**SYD0905: Winx Stand – Royal Randwick Racecourse  
Leger Lawn Development SSD-10285  
Additional Sydney Water Information**

This letter is to address the request for additional information regarding Sydney Water for the Leger Lawn Development SSD-10285. It addresses Water Servicing and Wastewater Servicing.

Figure 2: Proposed Sydney Water sewer main diversion works.

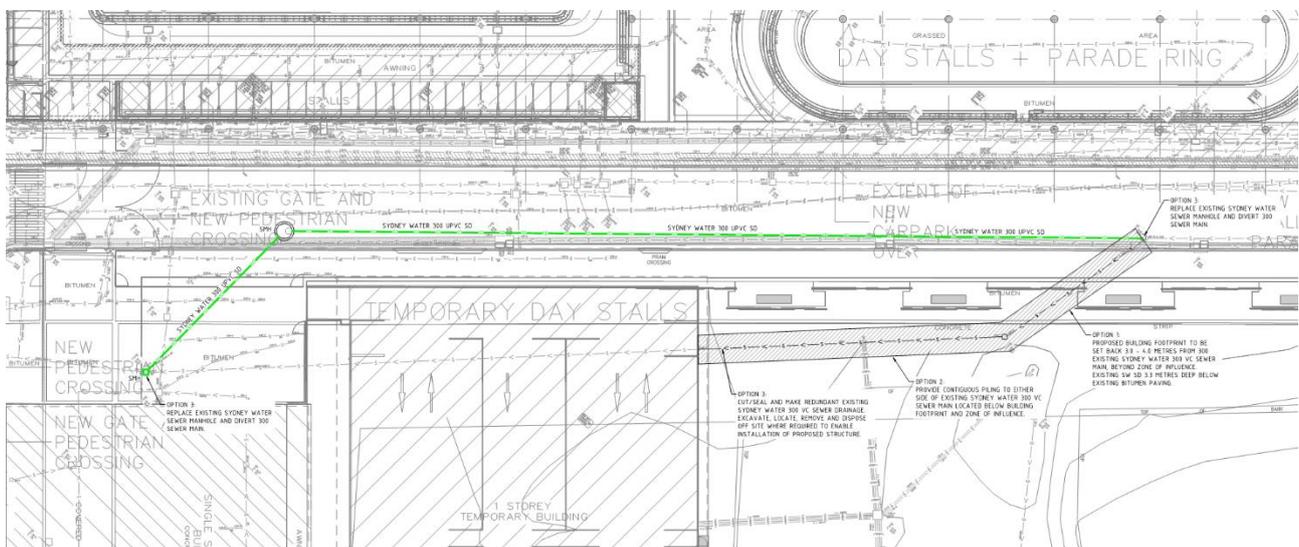
- > Wastewater servicing should be available to serve the development. Amplifications, adjustments, and/or minor extensions may be necessary.
- > As noted in the EIS the proposed stand is to be constructed over the existing DN225 sewer located within the site.
- > The EIS suggests that deviating the main is the only option. No discussion of the future status of the deviated main was included. It may serve the needs of both Sydney Water and the Trust if the affected sections and any upstream sections of main came under the ownership of the Trust.
- > The detail of the proposed changes to the DN225 sewer must be included in the Section 73 application.

A diversion to the existing sewer service is proposed and has been documented by the Water Servicing Coordinator to avoid the project being constructed over the existing asset. No amplification of the supply is required.
